Response to Planning Application

Application ref: LU/246/24/PL

Description: Demolition of existing structures and development of land to create 10 No. residential dwellings, landscaping, access, car parking and cycle parking. This application may affect the setting of listed buildings, is in CIL zone 2 and is CIL liable as new dwellings.

Location: Land at Toddington Lane Littlehampton BN17 7PN

**Figure 1.** Proposed landscaping plan for the development at Land at Toddington Lane, reproduced from Studio gb, dated September 2024 (drawing no. TLN-SGB-00-GF-DR-L-101).

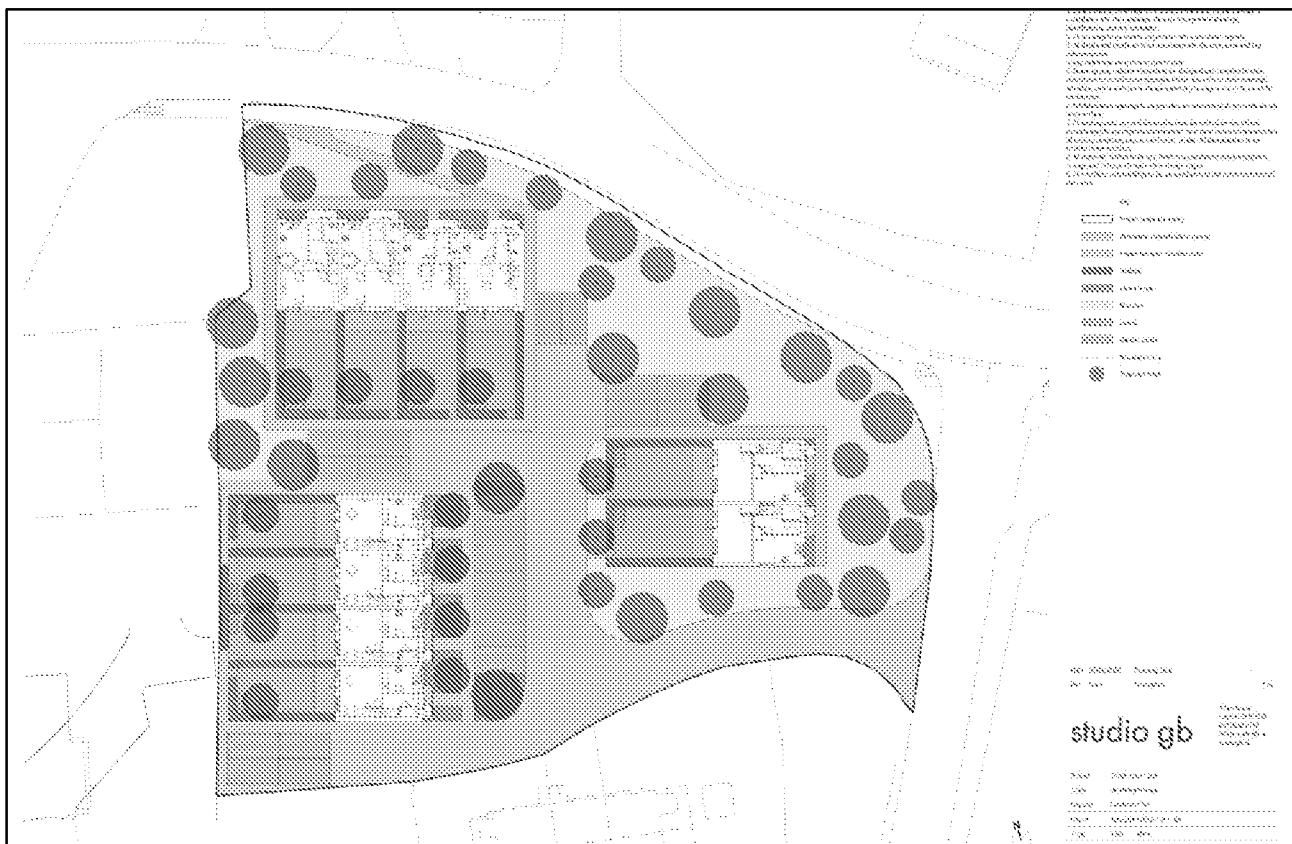
A site plan, Landscape GA L-101, Planting strategy, Landscape Statement and Design and Access statement have been submitted. The detail provided within these drawings is indicative only and would require further landscape drawings to detail actual quantities, planting densities and size at time of planting.

With a development of 10no dwellings, Public Open Space is not a requirement, however **developments of 9 or more dwellings are required to provide on site provision of LAP facility and therefore suitable location and quantum of greenspace to accommodate this.** LAP provision is not indicated on the plans and would be a requirement, which would need to be shown. Location of the indicated open area surrounding the semi-detached plots is banked or adjacent to a roadway and therefore may not be suitable location for LAP provision.

It is noted that much of the green infrastructure proposed is located within private garden locations, with trees and hedges which have the potential to be removed by the residents and therefore not a guaranteed long stay of the scheme. This in turn will effect Biodiversity Net Gain calculations. Green infrastructure proposals should be included within the site outside of private dwelling remits.

The landscape scheme submitted within the DAS is indicative only and will require plan submission of proposals to include quantities, species choice, position, densities and size at time of planting. This detail is required in plan and list form and in relation to existing trees and vegetation retained in order to give a clear and adequate picture of the proposals..
